# DELEGATED HOUSEHOLDER DECISION

Item No.	Report of the Head of Development Management and Building Control	
Address:	60 MARLBOROUGH AVENUE RUISLIP	
Development:	Erection of a single storey rear extension and conversion of roofspace to habitable use to include roof extension and alterations to roof profile, Juliette balcony, 1no. rear dormer, 2no. front dormers and 1no. front rooflight and amendment to fenestration (revised description)	
LBH Ref Nos:	78424/APP/2023/3490	
Drawing Nos:	ELA/6 Rev A ELA/13 Rev A ELA/14 Rev A ELA/17 Rev A ELA/1 Rev A ELA/2 Rev A ELA/3 Rev A	
Date Plans received:	01-12-23	Date(s) of Amendments(s):
Date Application valid	01-12-23

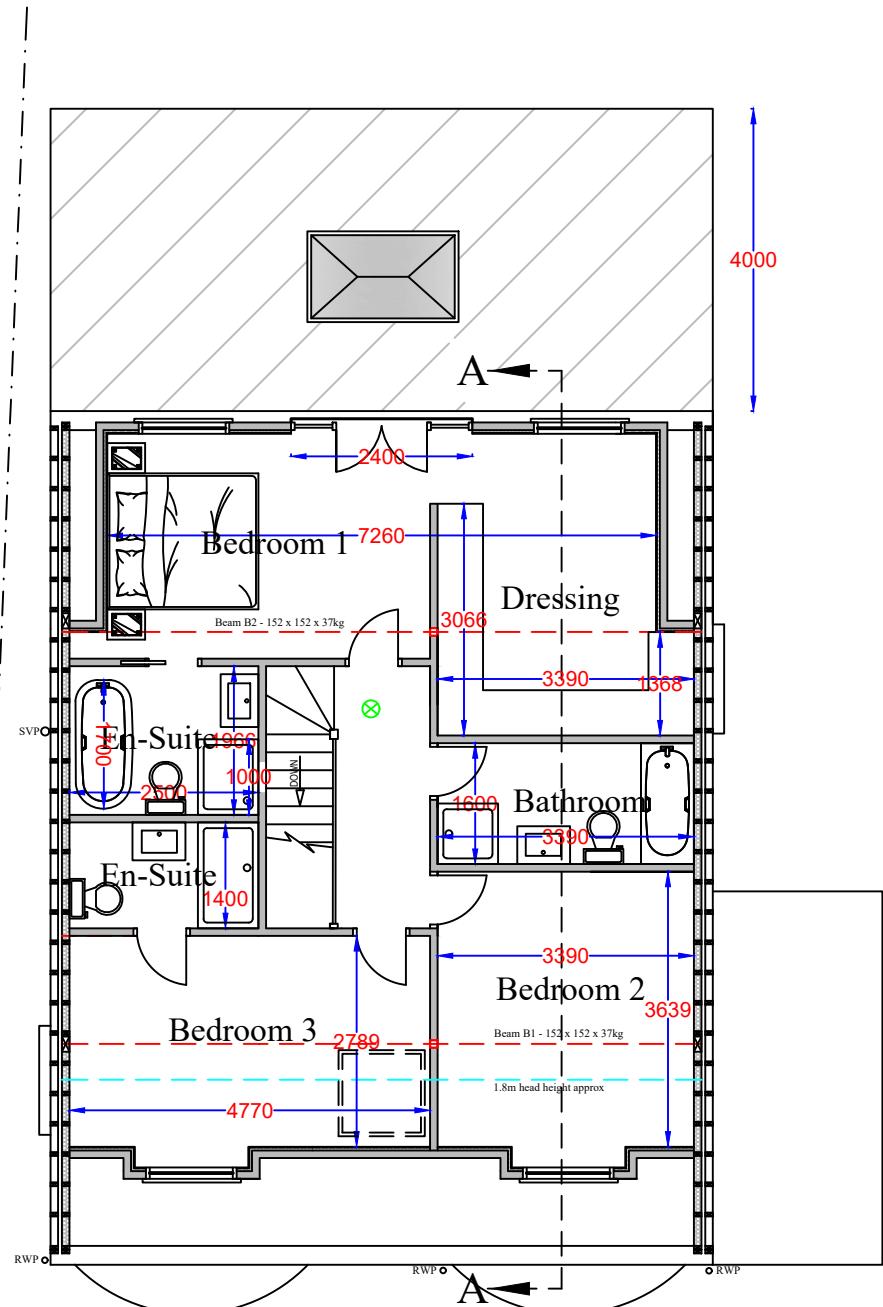
The application proposes a single storey rear extension which would extend 4m deep, 3m high and full width, complying with Policy DMHD 1 of the Hillingdon Local Plan: Part Two - Development Management Policies (2020).

In addition, the application is proposing a conversion of roof space to habitable use including a roof extension and alterations to roof profile with a large crown and two front dormers and one large dormer. The proposed roof extension would create a new storey to the main dwelling with three new habitable rooms and three bath/shower rooms on the new first floor. The new roof form would be a mansard style with gable ends and a flat top.

Drawing:
Proposed Elevations

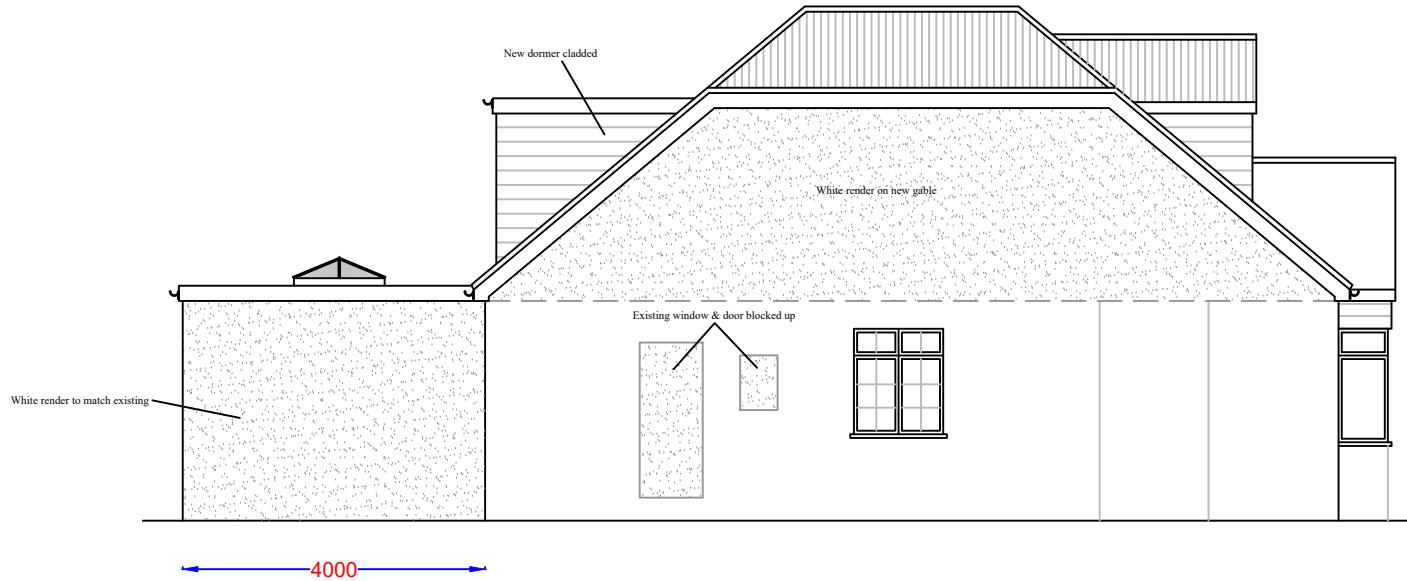
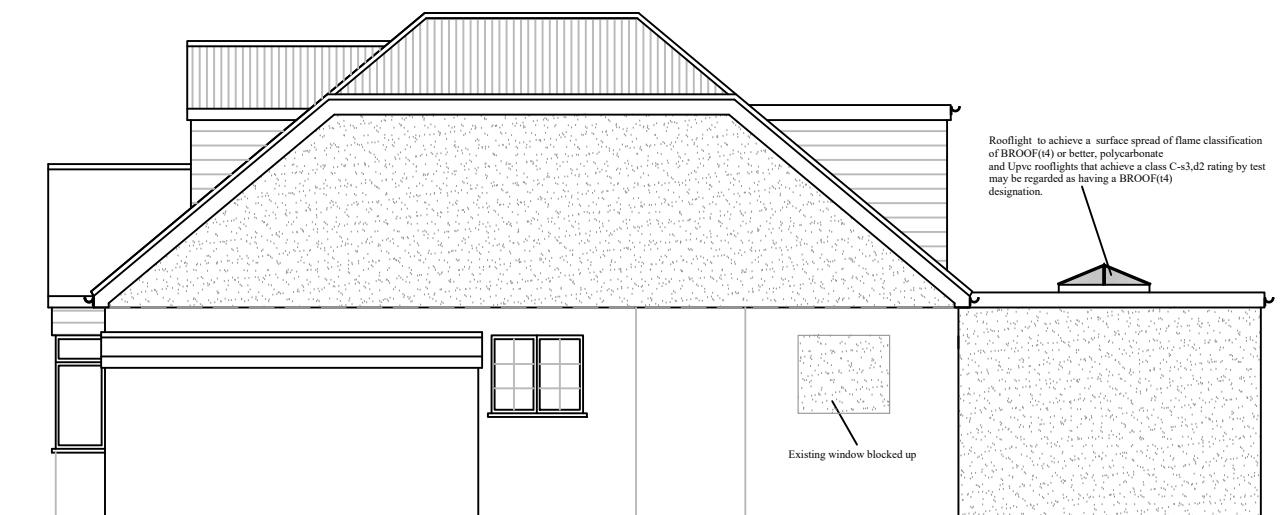
The proposed rear dormer is not subservient in scale and exceeds more than two thirds of the original roof, failing to comply with policy DMHD 1. In addition, the two front dormers are out of character when compared to other bungalows in the area, the majority of which have one centralised front dormer. Further, there are no examples of crowns/flat top roofs within the immediate area nor of this scale.

While it is noted that the two neighbouring dwellings are both two storey detached properties, the roof alterations, when viewed as a whole, would appear out of character with the surrounding area, where the vast majority of properties have retained their hipped roof forms, including bungalows with the same distinctive gable features to the front. The proposed mansard roof and dormers would compete with and detract from the existing modest roof profile. In this context, it is considered that the roof form would result in an incongruous and insubordinate development that fails to respect the character of the area. Therefore, the significant increase in the overall size, prominence, scale, bulk and massing of the host dwelling would result in a development that would not appear subordinate and out of character.

Therefore, it is considered that the proposed development, when viewed as a whole, would be completely disproportionate, overly prominent and unsympathetic to the original architectural composition of the host dwelling, resulting in the proposed development having a harmful impact to original dwelling, and the character, appearance and visual amenities of the area. The proposal would therefore conflict with Paragraph 135b) of the National Planning Policy Framework (2023), Policies D3 and D4 of the London Plan (2021), Policy BE1 of the Hillingdon Local Plan: Part One Strategic Policies (2012) and Policies DMHB 11, DMHB 12 and DMHD 1 of the Hillingdon Local Plan: Part Two - Development Management Policies (2020).

The roof extensions, by reason of its excessive bulk, siting, scale, massing and design would be

unduly prominent, visually incongruous and unsympathetic to the original architectural composition of the host dwelling, resulting in the proposed development having a harmful impact to original dwelling, and the character, appearance and visual amenities of the area. The proposal would therefore conflict with Paragraph 135b) of the National Planning Policy Framework (2023), Policies D3 and D4 of the London Plan (2021), Policy BE1 of the Hillingdon Local Plan: Part One Strategic Policies (2012) and Policies DMHB 11, DMHB 12 and DMHD 1 of the Hillingdon Local Plan: Part Two - Development Management Policies (2020).
